## **SECTION 4.55(1A) MODIFICATION APPLICATION BUILDING R4B – SSD 8892218**

This modification application has been prepared by Ethos Urban on behalf of Lendlease (Millers Point) Pty Ltd, pursuant to section 4.55(1A) of the *Environmental Planning and Assessment Act 1979* (EP&A Act) to modify Development Consent SSD 8892218 relating to Building R4B Barangaroo South (the site).

Proposed Floor Levels on L64 and L65

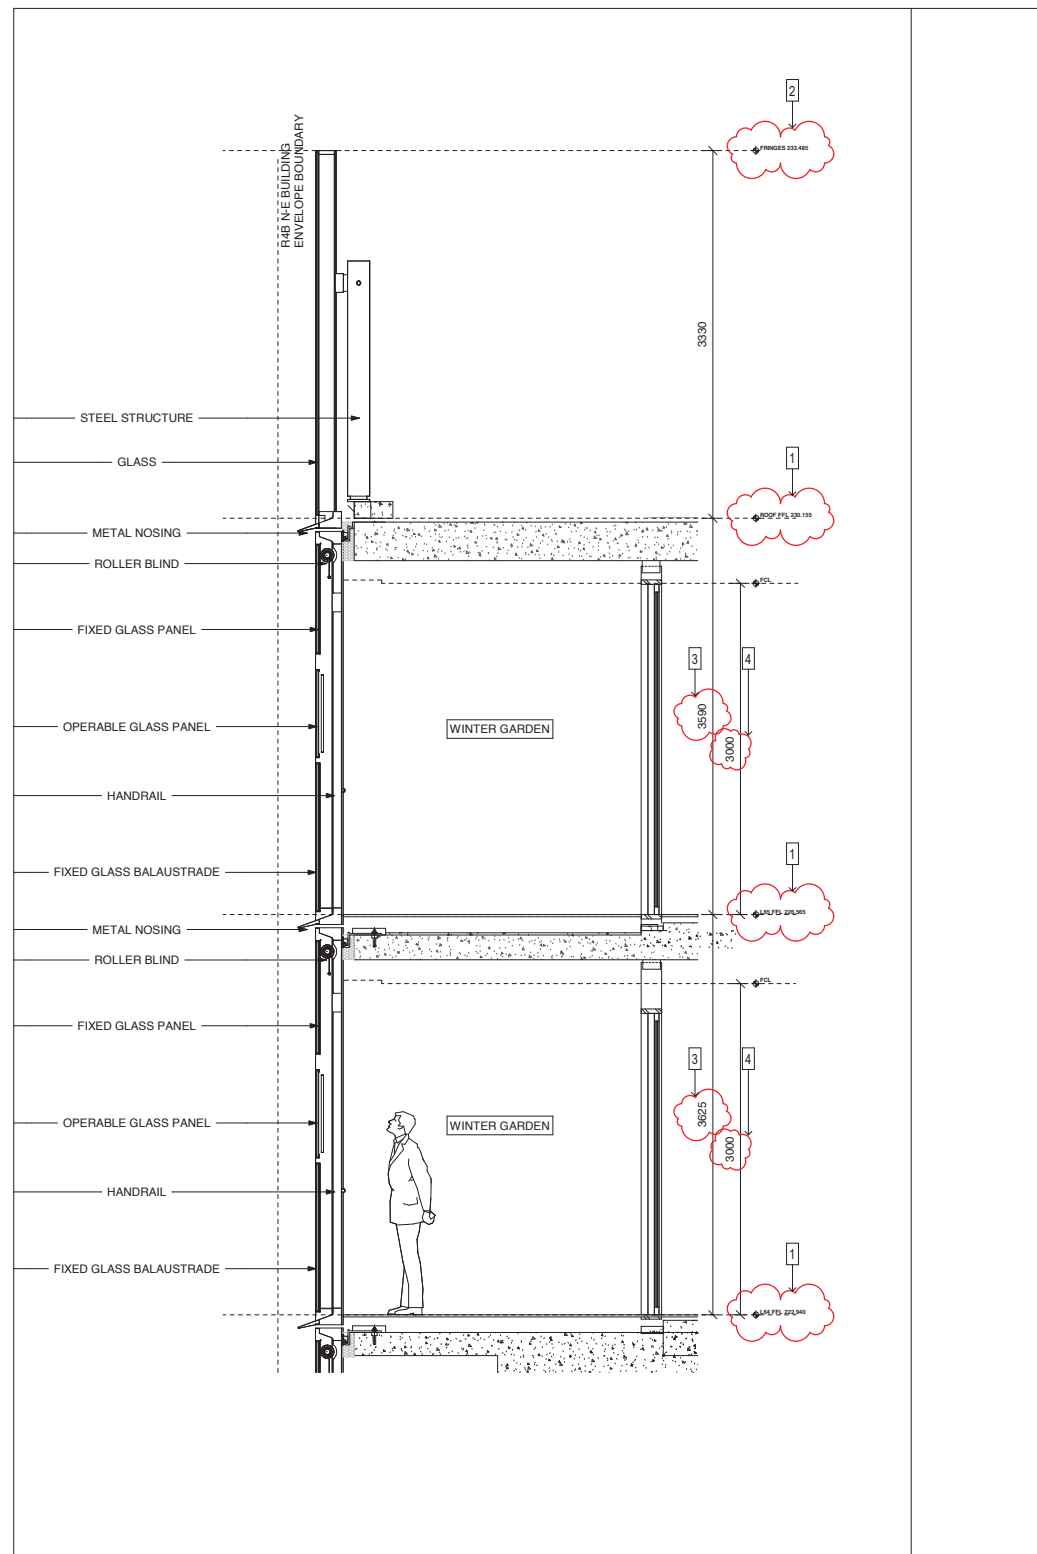
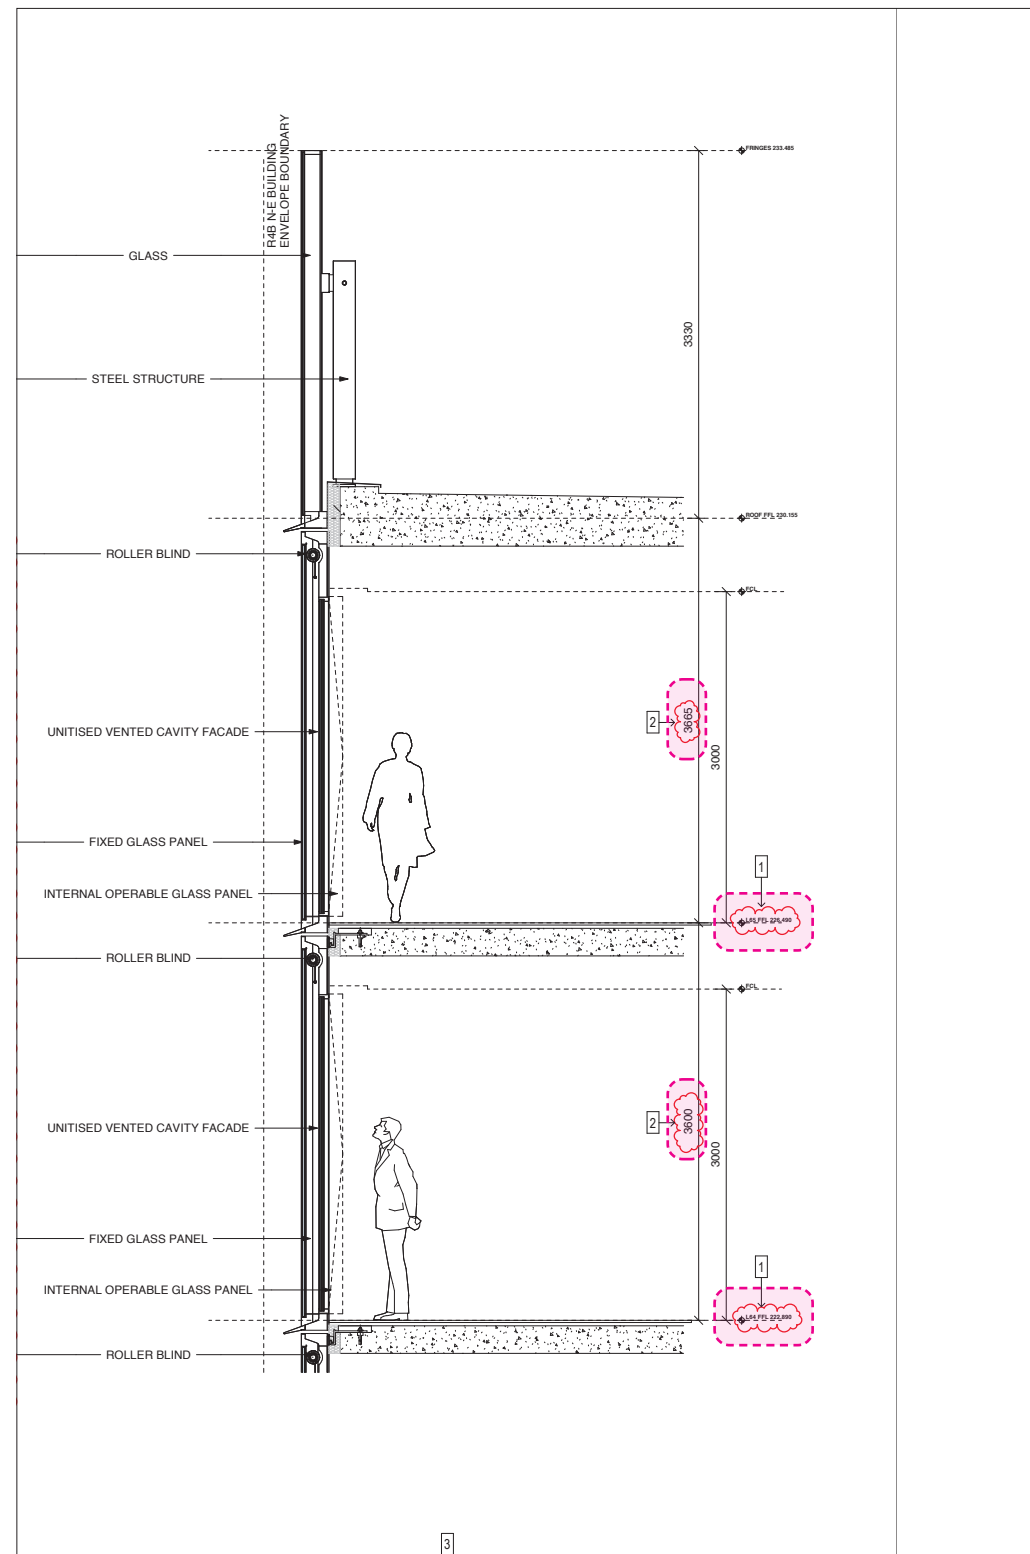
This modification application also seeks to reduce the finished floor level of Level 64 and increase the finished floor level of Level 65 by 50mm. This will not impact the finished floor levels of Level 63 below.

Proposed Facade - North-East Elevation

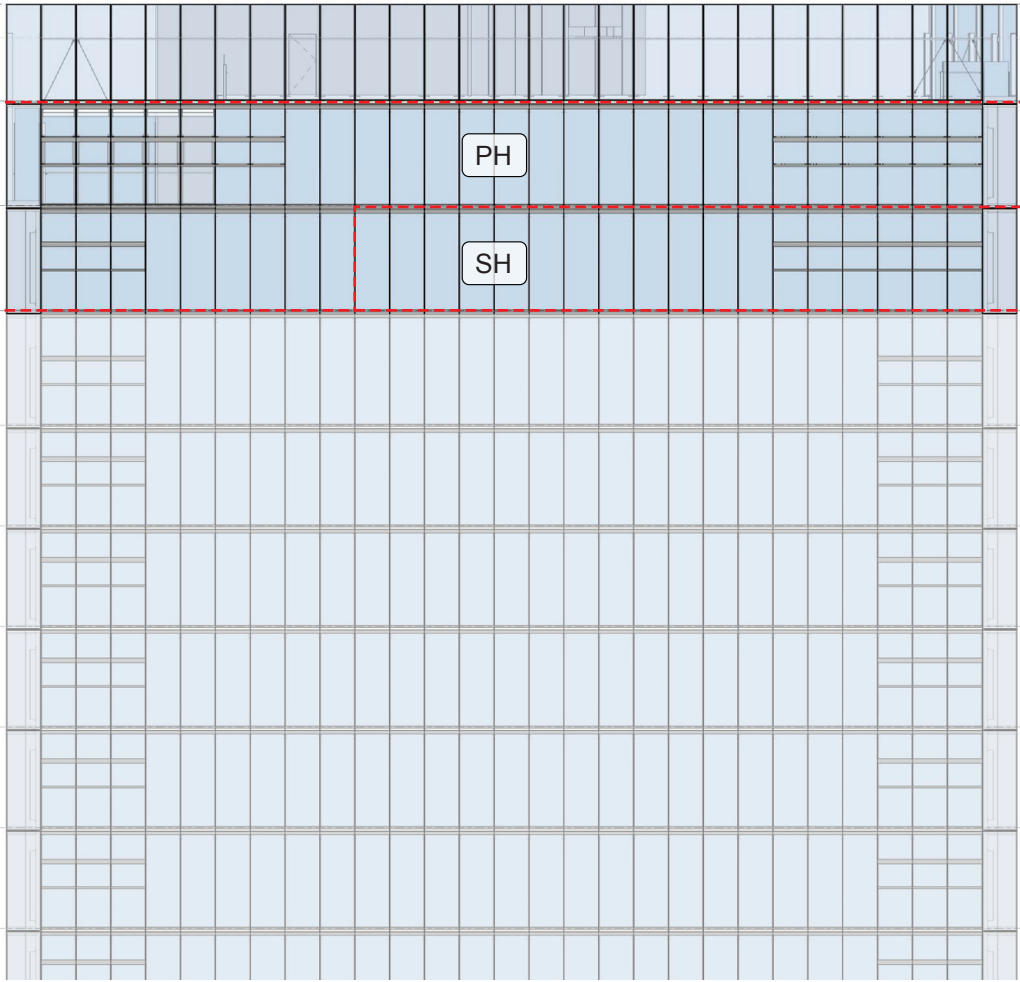
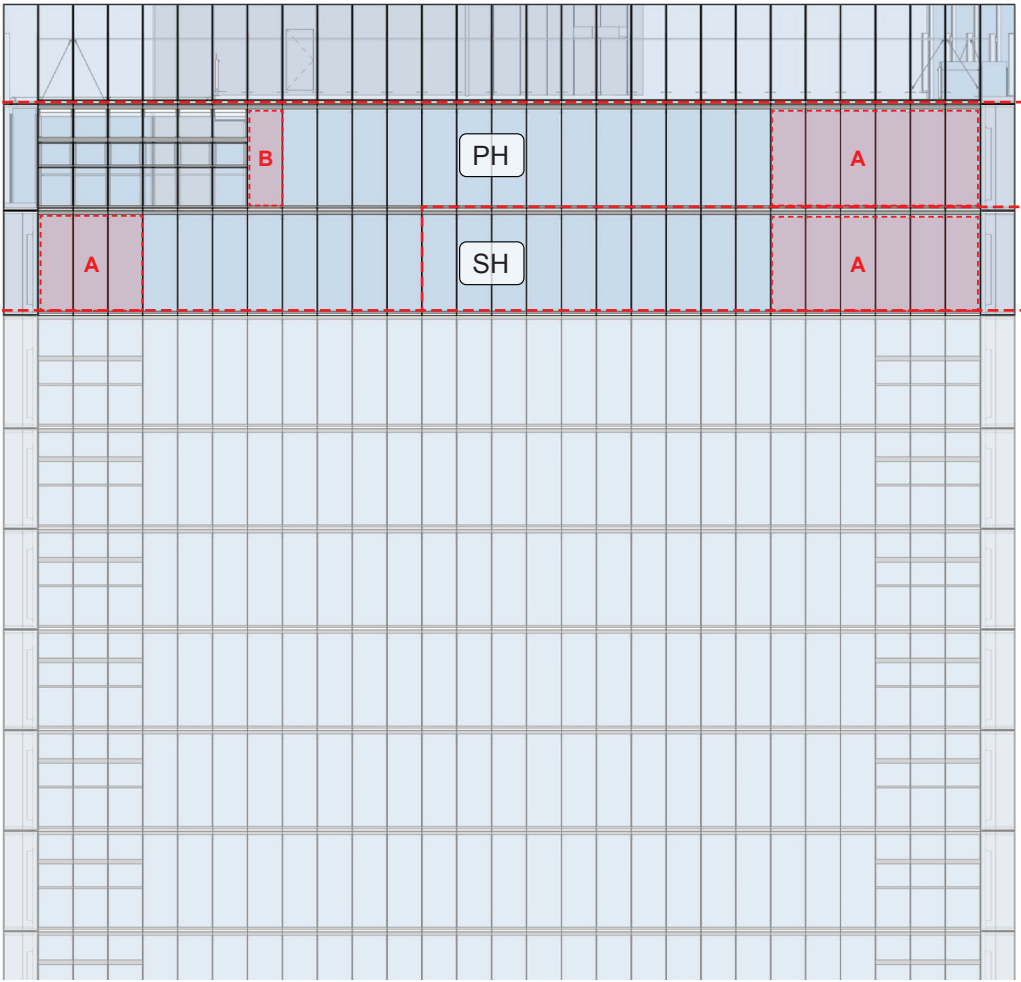
As part of the reconfigurations proposed on Level 64-65, a number of façade changes are proposed to the north-eastern and western facades. These changes include replacement of wintergarden panels with open cavity façade panels, which reflects the internal reconfiguration outlined above. These changes are shown in **Figure 6** and **Figure 7**.
